Planning Officer: Miss Z Toppin
Planning Application Ref: A/100/21/T
Location: Land to North of New Road, Angmering
Description of works: Fell 12no. Monterey pine trees
Reasons given: To restore mobile communications network coverage (EE)
Comments on Application:
12x Monterey pine / *Pinus radiata* Height: 15-20m Ave. radial spread: 5-10m

TREE OBSTRUCTION – MBNL CELL SITE 94578 TO 71569 (TREE AREA 1)

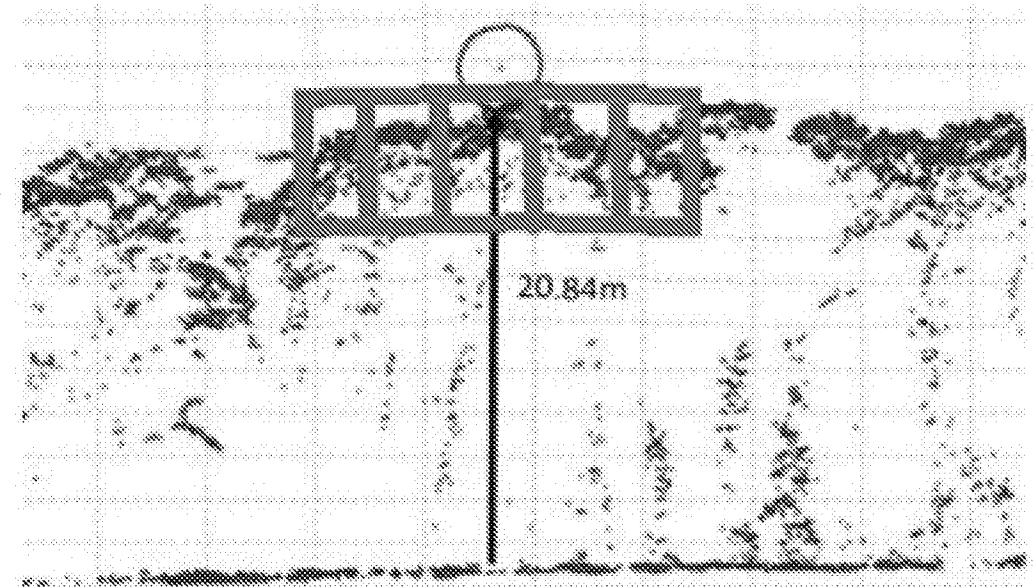
- Pine trees are intolerant of hard pruning and the extent of height reduction required to restore coverage to EE's existing mobile communications infrastructure would effectively destroy them. Subsequently we are dealing with an application to fell those trees to ground level.

- The work proposal has not been justified on arboricultural grounds. These are high profile trees of significant landscape and visual amenity; whose value extends beyond their own individual worth; contributing to and benefiting from root and crown cohesion with the rest of the group.
- Beyond the obvious and immediate impact to the landscape, suddenly exposing such aged trees to the full force of prevailing winds is likely to wreak havoc in their crowns from which they cannot recover and potentially resulting in further erosion of the group.
- On balance, it seems reasonable to expect the provision of full network coverage be achieved by enhancing existing infrastructure rather than negatively impacting such an important landscape feature.

- I recommend **REFUSAL** for this application.

Tree Area 1

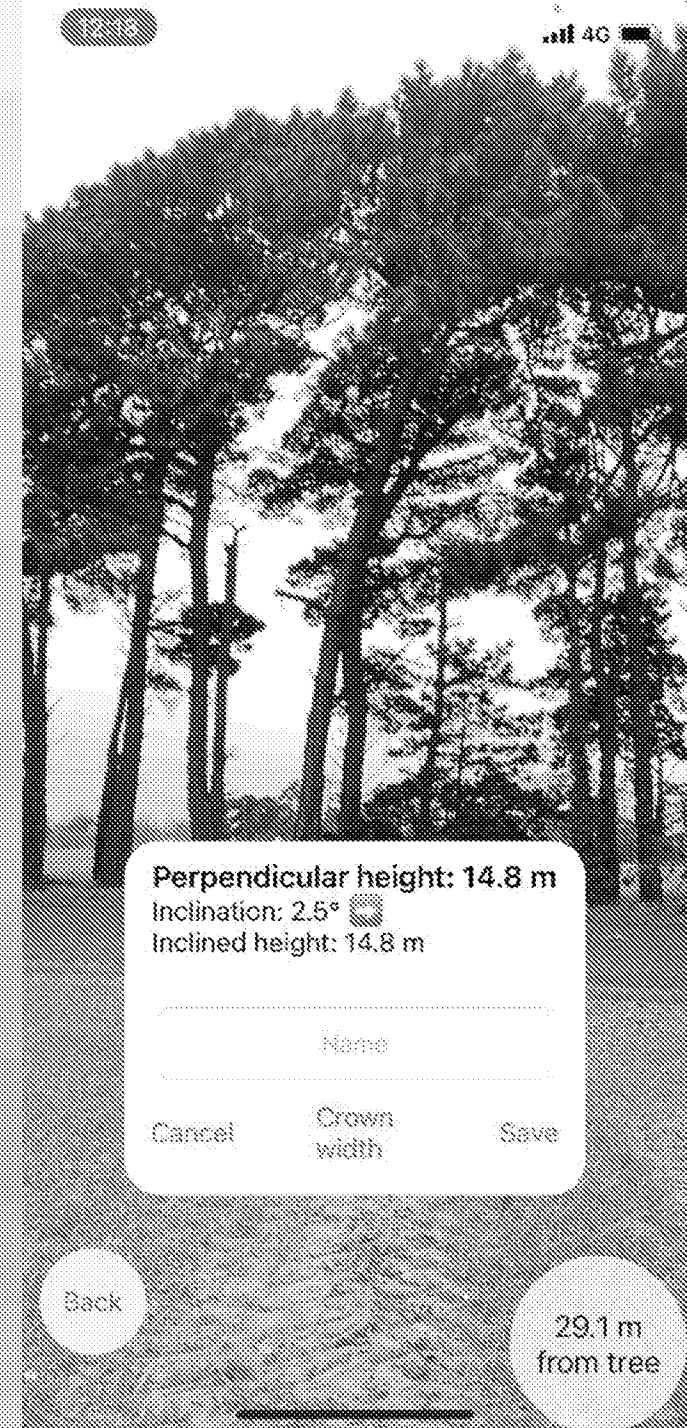
- These trees are important constituents of a long-established and prominent landscape feature. This broad belt of evergreen trees provides 230metres of continuous high canopy, which provides great visual amenity.
